December 18, 2009

RE: Benveniste Setback Variance, VA-09-00015

Joe Gilbert, EH Specialist II
Kittitas County Public Health Department

SITE PLAN

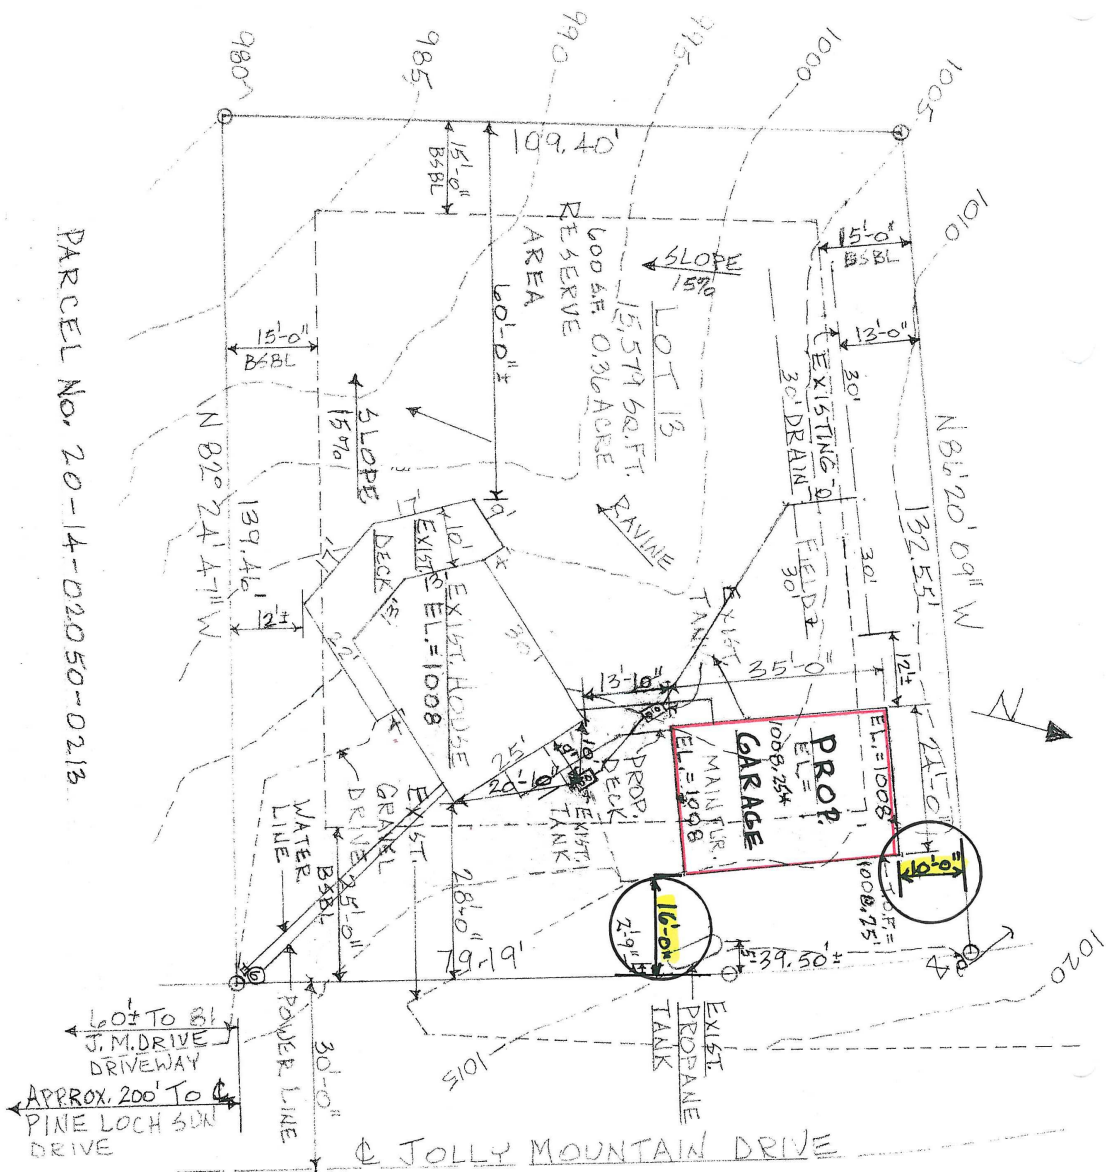
I am commenting in regards to the Benveniste Setback Variance Request, VA-09-00015. After review of the site plan provided by the applicant and review of the existing On-Site Septic Permit information, it appears that the proposed structure, in which requires the variance, would be placed directly on and around the reserve septic soil log and dedicated reserve drainfield area defined in the OSS permit issued on 5/8/95 to David Marsh #20-14-02050-0213.

Although, septic approval would not be required until a building permit is applied for, it seems appropriate to resolve this issue prior to issuing a variance for a structure that would be built over the dedicated reserve drainfield area.

In order to identify a new reserve drainfield area, the applicant must contact a licensed septic designer to schedule an OSS Site Evaluation with the Kittitas County Public Health Department (KCPH). Once the Site evaluation is complete, a Site Plan drawn by licensed septic designer will be reviewed by KCPH and the file will be updated if found acceptable.
